SSD-83870463 | 15A-15B Moseley Street and 25-31 Donald Street, Carlingford | Review of Response to Submissions

The purpose of this letter and the supporting documentation is to provide a response to the request for additional information (**RFI**) letter provided by Department of Planning, Housing and Infrastructure (**DPHI**) on 22 January 2026. Amended and/or updated documentation has been included with this response as follows.

Rev	Date	Description	BY
2	03.02.26	ADDITIONAL INFORMATION ADDED	FT
1	26.11.25	ISSUED FOR SSD APPLICATION	FT

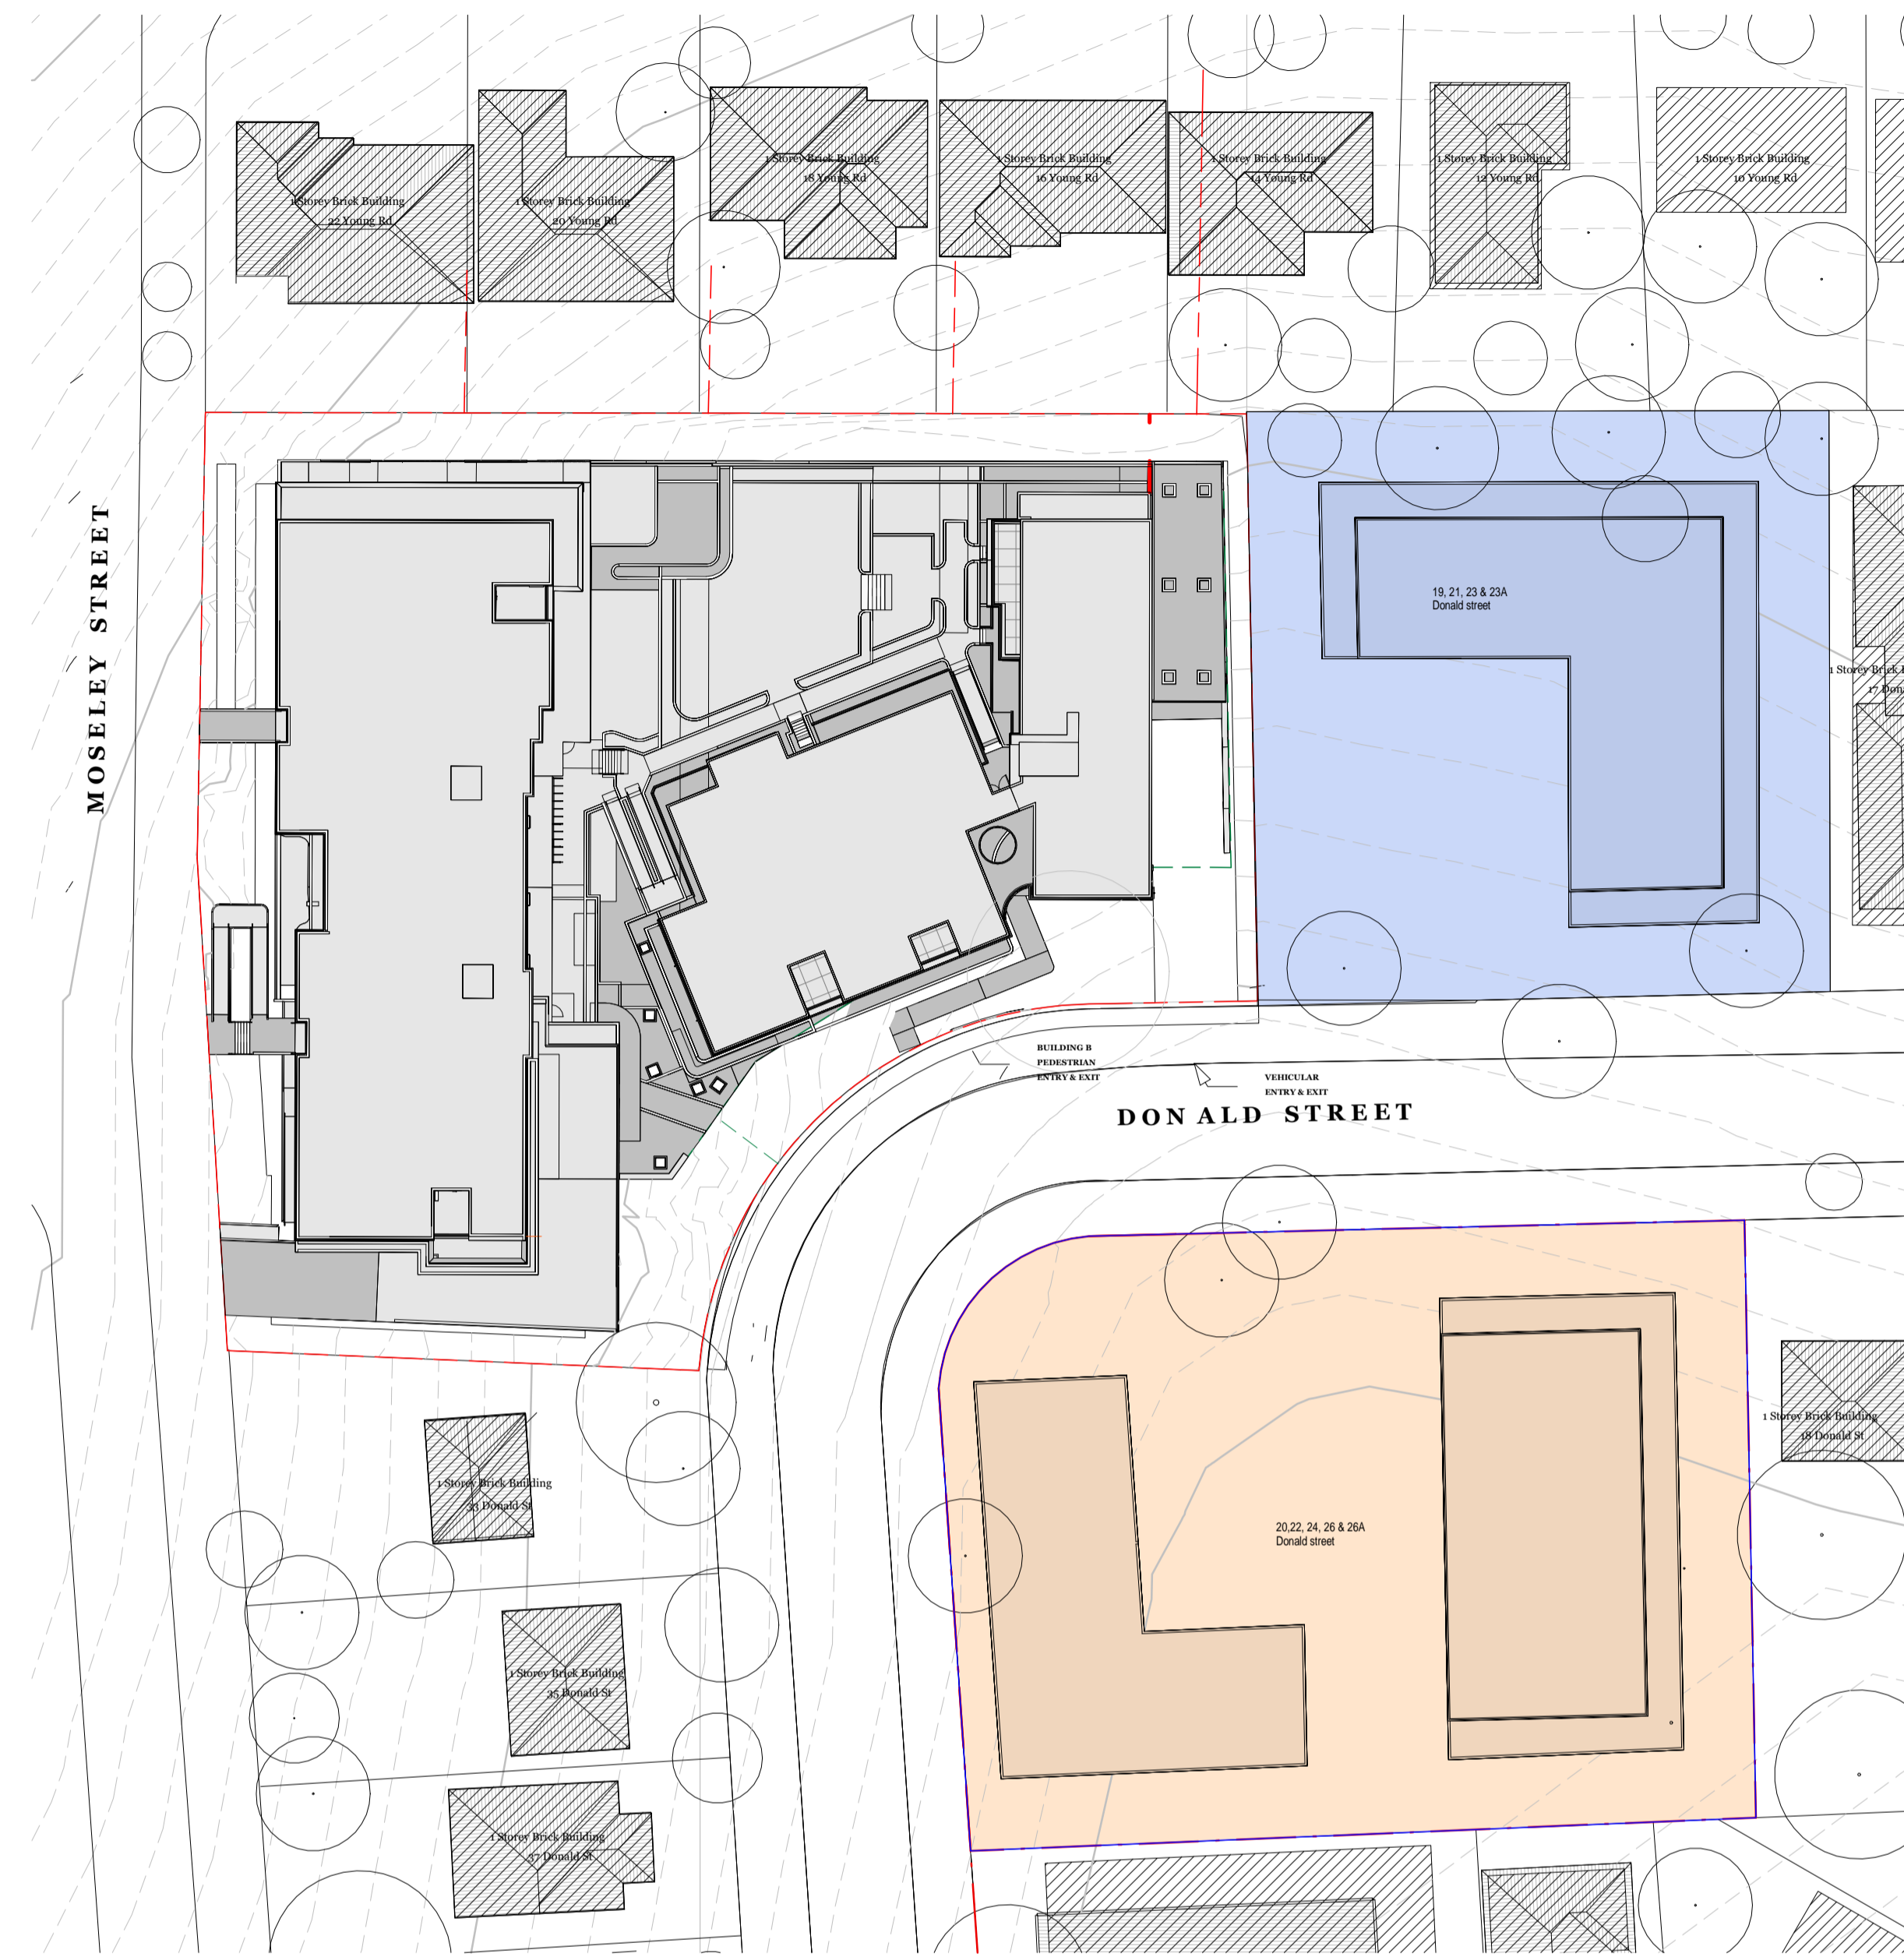
Issue	DPHI Comment	Project Response
Low and Mid-Rise (LMR) Provisions	<ul style="list-style-type: none"> ▪ <i>As previously advised (on 20/11/2025 and 23/12/2025), the amended design, which does not comply with the Height of Building or FSR standards, directly impacts the neighbouring properties to the south-west on Donald Street. It is critical that the amendment report specifically addresses these impacts, particularly through a more detailed solar access analysis for the affected properties.</i> ▪ <i>The analysis provided to date is insufficient to allow a robust assessment of the proposal. Please therefore revise the amendment report package to address the following:</i> <ul style="list-style-type: none"> – <i>The sun eye diagrams must clearly show the massing of all adjoining properties that are being impacted (overshadowed) by the development</i> – <i>The solar access analysis must include consideration of how the overshadowed properties on Donald Street would be affected if they are developed under the LMR.</i> 	<p>The amendment report has been updated to provide a more thorough assessment of solar impacts to properties on Donald Street to the south (see Section 5.1.3).</p> <p>Additional sun eye diagrams have been prepared which provide a consideration of how the overshadowed properties on Donald Street would be affected if they are developed under the LMR. This has been done by preparing two hypothetical development scenarios under the LMR controls and including these into the existing sun eye diagrams. While the impact at 9am on both hypothetical scenarios is noted, it quickly reduces at 10am and 11am respectively. By 12pm, the sun eye diagrams clearly show there is no impact from overshadowing created by the project on these sites.</p> <p>Refer page 50–56 of the Architectural Design Report.</p>
